Response to Submissions

State Significant Development Application (SSD 7564) Proposed Warehouse/Distribution and Industrial Facility

Lot 2, Horsley Drive Business Park (Lots 23 (part), 24 (part), 25, 28B, 30, 30A, 30B, 32 & 32A in DP 13961; Lots 1-5 in DP 1098128; Lot 100 in DP 879680; Lot 1 in DP 1036933; Part Lot 10 in DP 879209; and Lot C in DP 103755)

EROSION AND SEDIMENT CONTROL PLAN
SCALE 1:500

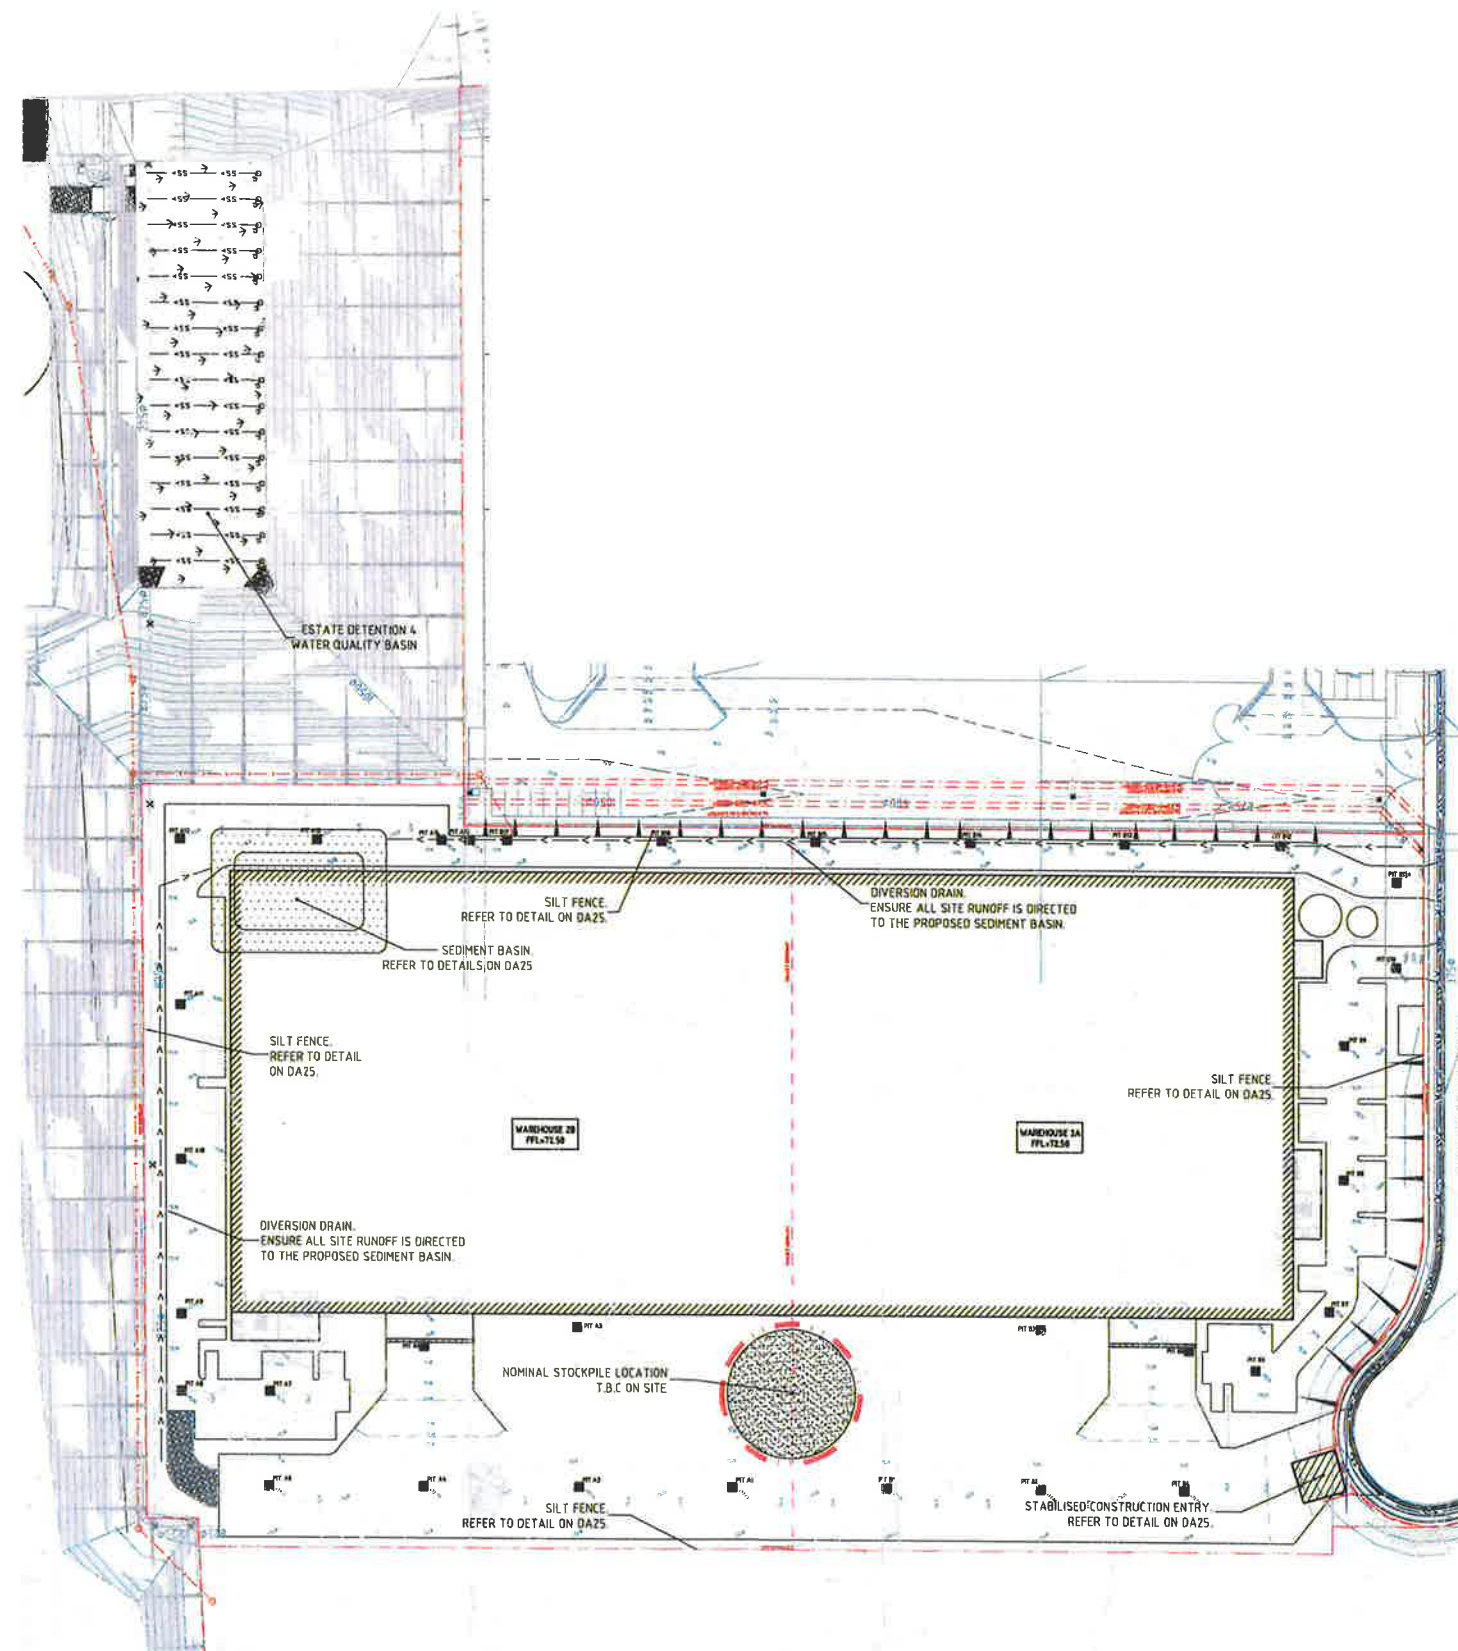
c) Environmental Protection <i>i. The CEMP states that construction hours will be:</i> <i>Monday to Friday: 7.00 am – 6.00 pm</i> <i>Saturday: 8.00 am – 1.00 pm</i> <i>It also states that the site will open earlier and close later where required, but does not state what these hours are or what works will occur during these hours.</i> <i>ii. The ESCP shows details of a sediment basin. Operational notes include details of the assessment of water for sediment concentration and treatment for flocculation of sediments prior to discharge to stormwater. No mention of any required pH adjustment is made.</i> <i>iii. Section 4 is titled Assessment of Environmental Risk. It</i>	Where required, construction hours will vary from that set out in the CEMP to allow site set up and shut down. In the morning, it will be a maximum of 30 minutes prior to scheduled commencement (6:30am Monday to Friday and 7:30am on Saturday) and in the evening/afternoon, 30 minutes after the scheduled closing time (6:30pm Monday to Friday and 1:30pm on Saturday). pH requirements are called up in the Sediment Control Pond Notes included in the sediment control drawing (DA25) submitted with the EIS (refer attached at Appendix 1). Note 11 on this plan stipulates that pH is to be within the range of 6.5-8.5 for water to be permissible for discharge. Explanation of the risk levels has been included at Appendix 2 in the amended

<i>includes a Ratings Matrix, which evaluates the potential consequence vs the likelihood of an occurrence, and assigns a 'Significance' rating. No further references are made to this Ratings Matrix.</i> <i>4.2 is a table titled 'Evaluation of Environmental Risks'. The table divides works into the various phases of construction (initial site setup, civil works, footings, etc), environmental aspects of works (dust, water discharge, waste, etc) and potential impacts.</i> <i>It also includes a column titled 'Risk Level*', where all points in the table are given a 'Risk Level' of 5 or 3. There is no explanation of what these risk levels relate to.</i> <i>Another column is titled 'Environmental Control (ref to procedures/ guidelines)'. There is no reference in any of the stages of construction to sediment and erosion controls, dust suppression or the prevention of tracking of mud or dust onto adjacent roadways. No procedures or guidelines are referenced. References to these controls have been included in the 'Objectives' column.</i> iv. <i>Council's Environmental Management Branch has determined that insufficient information has been submitted for SSD 7564. Prior to further assessment, the following information is required, including:</i> <i>• Site plans showing the location of all environmental controls, including shaker pads, refuelling areas, and washout areas;</i> <i>• Details of any required pH adjustment of sediment basin water prior to discharge.</i>	CEMP dated 1 August 2016 (Rev 2) as follows: L = Low Significance = 5 M = Moderate Significance = 4 S = Significant Effect = 3 H = High Significance = 2 C = Critical Significance = 1 The revised rating criteria provides an explanation of what the risk levels relate to for the construction phase of the proposal so that the CEMP can be comprehensively reviewed and from part of the SSD Approval. Shaker pads are shown as stabilised construction entrance on the civil engineering drawings attached (Appendix 1), refueling and washout area activities will be undertaken adjacent to the stockpile shown on the civil engineering drawings attached. The pH of sediment basin water discharge will be between a pH of 6-8.
